From: Amanda Scholes on behalf of Planning.Responses
Sent: 12 March 2018 09:29
To: Planning Scanning
Subject: FW: 12 Raleigh Road

From: Gary Smith [REDACTED]
Sent: 26 February 2018 11:38
To: Mark Jones
Subject: Re: 12 Raleigh Road

Can you confirm if the new roof over the garage at No.10 is part of the current application.

Proposed Garage and Utility room. 12 Raleigh Road, Bognor Regis, West Sussex
Proposed Elevations. Drawing Number = 11 Scale 1:100 @ A4

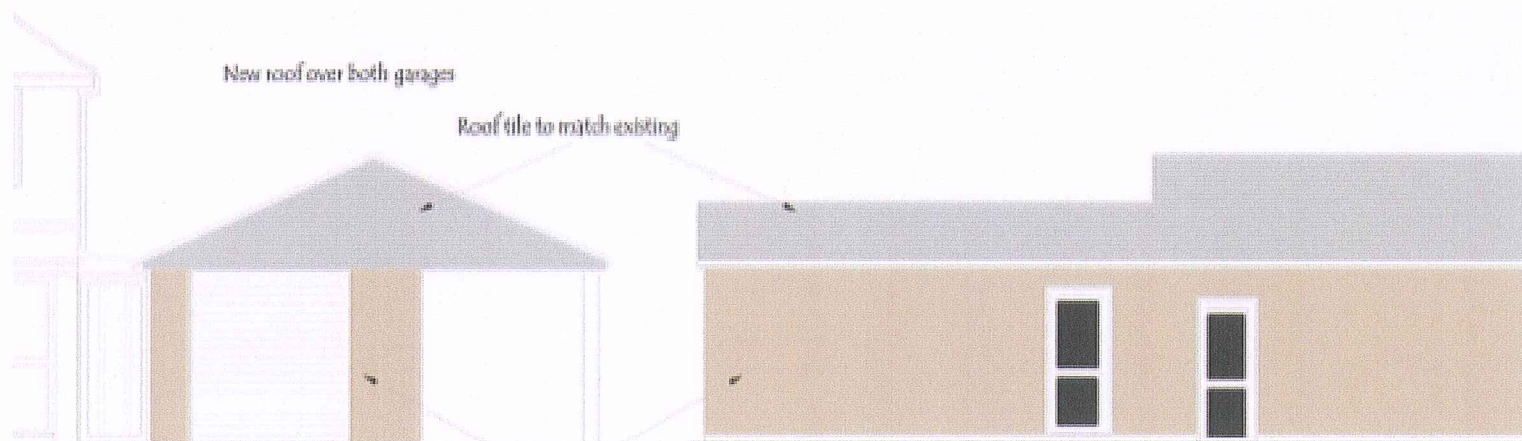
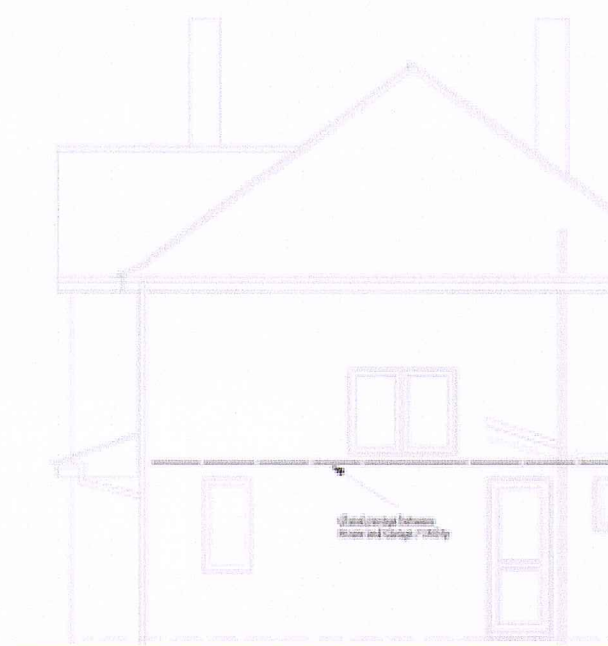
How do progress as roof on 10 is straddling a party wall ?

If I continue with current then all walls on 10 changed, would council be happy to contribute ?

If change to any other roof solution then no 10 will need to be altered .

1. The plans are amended to remove the proposed roof on the neighbouring property No.10 and make a separate application for No.10 or leave No.10 out of consideration.

2.The application form changed to reflect 10 and 12 including the description . In addition the red line would need to change on location plan to include No.10. Also certificate B would be required if the application is in your name and notice served on the owner of No.10, as mentioned these forms can be obtained on the planning portal. We would need to agree an extension of time for the application to allow a revised application to be re advertised.
